**Re: Liverpool City Council's Review of Response to Submissions for SSD-10446,
275 Adams Road, Luddenham**

State Significant Development - SSD 10446 – Development of an advanced resource recovery facility warehouse and associated external works including a link road to the site at 275 Adams Road, Luddenham NSW 2745.

ELIZABETH DRIVE - ADAMS  
ROAD INTERSECTION  
UPGRADE

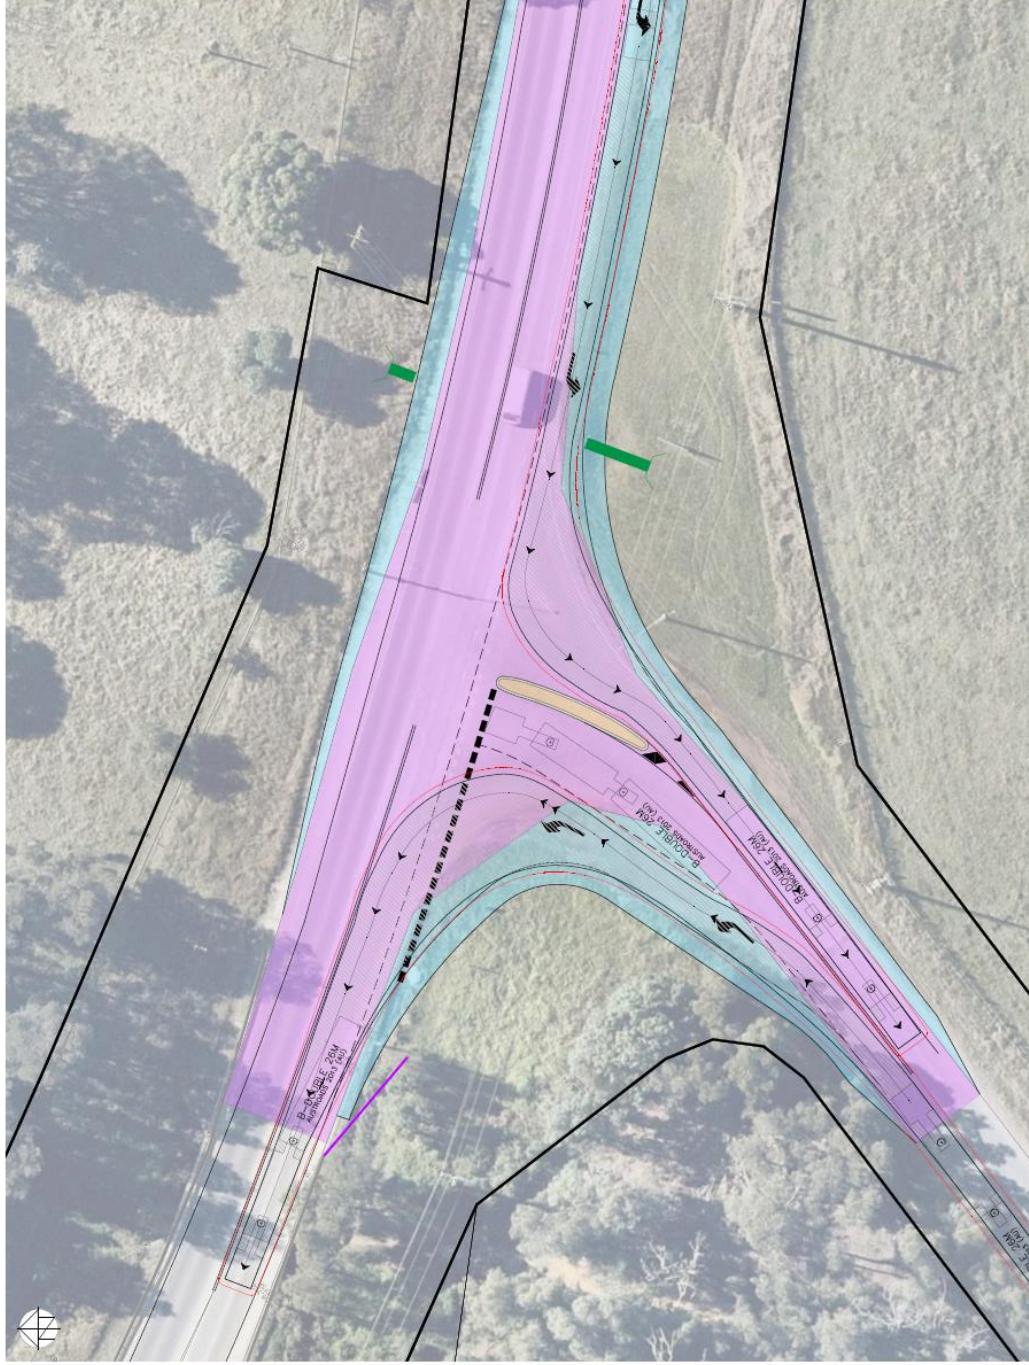
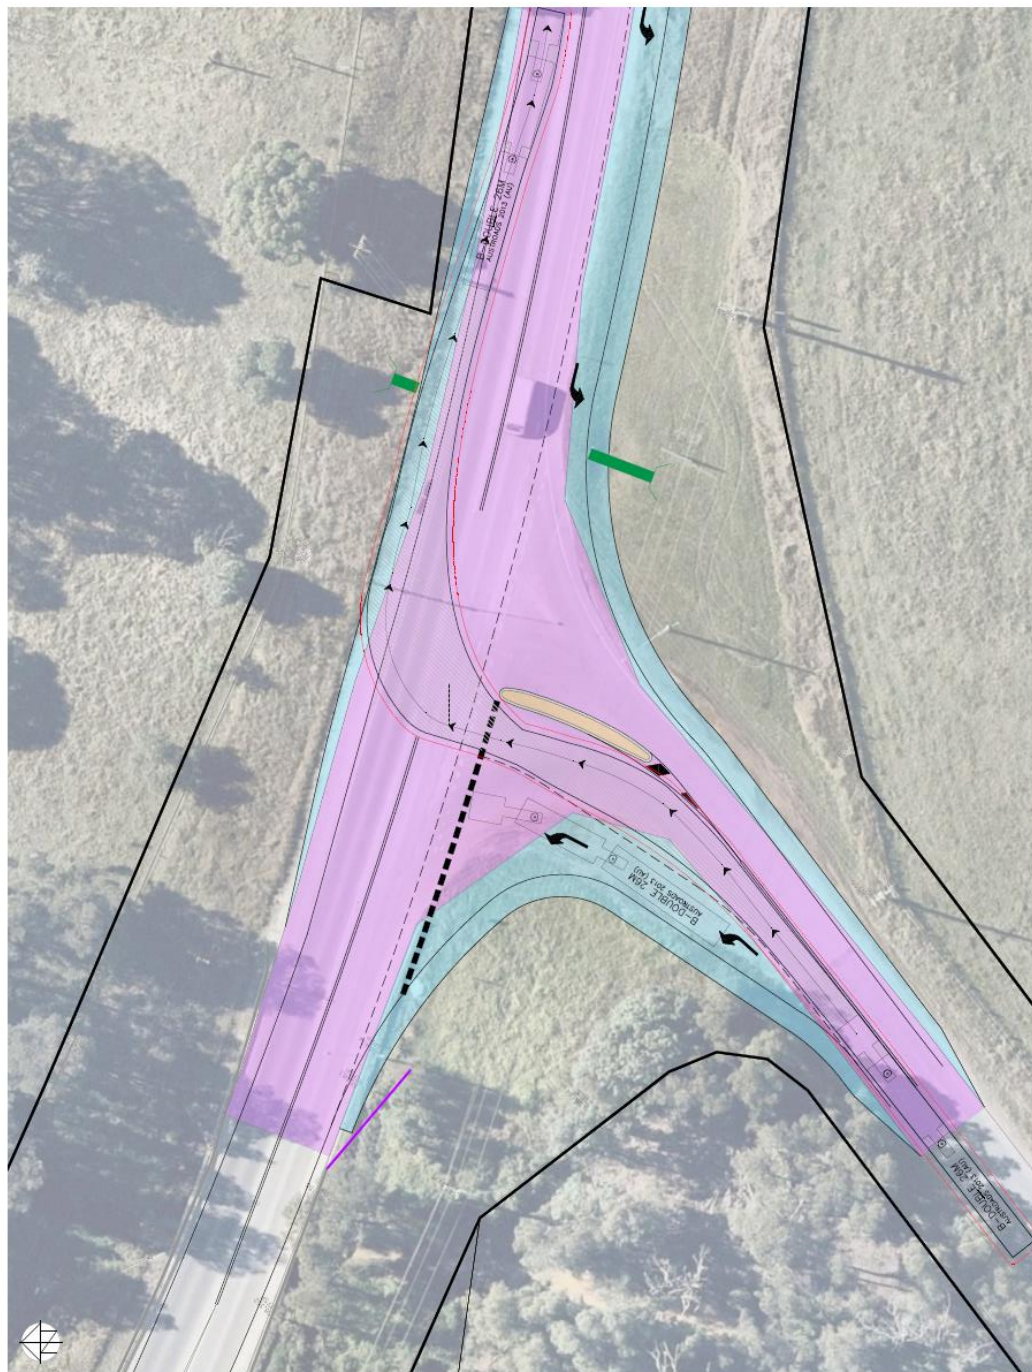
3. Elizabeth Drive is a classified road. TfNSW approval is required for the following proposed interim treatments at the intersection of Elizabeth Drive/Adams Road prior to the determination:
 - a) Provision of a 90 m deceleration left-hand turn lane into Adams Road;
 - b) Provision of a short left-hand turn land on Adams Road into Elizabeth Drive; and
 - c) Removal of the right-hand turn from Elizabeth Drive west into Adams Road.

As the intersection of Elizabeth Drive/Adams Road will be restricted to left in only for light vehicle, Council recommends that this intersection be restricted to left in/left out only for the operation of ARCC.
